CITY OF PORTLAND

BUILDING PERMIT

Job ID: 2011-07-1759-ALTR

has permission to build a 16 by 31.5 foot addition (Single Family Residence).

Job 639023	Truss 001	Truss Type ATTIC	Qty 1	Ply 1	Job Reference (optional)
---------------	--------------	---------------------	----------	----------	--------------------------

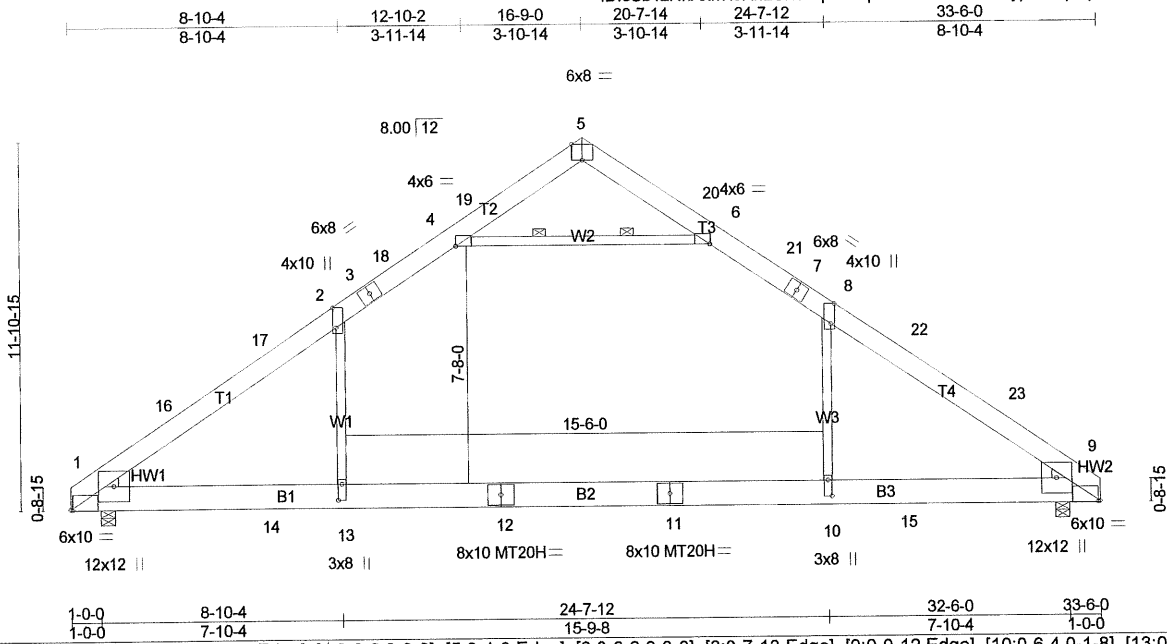
Are the overall height & dimensions staying the same with the truss design? Is the sheathing 5/8 inch with Asphalt? JGR.

That's a yes on everything
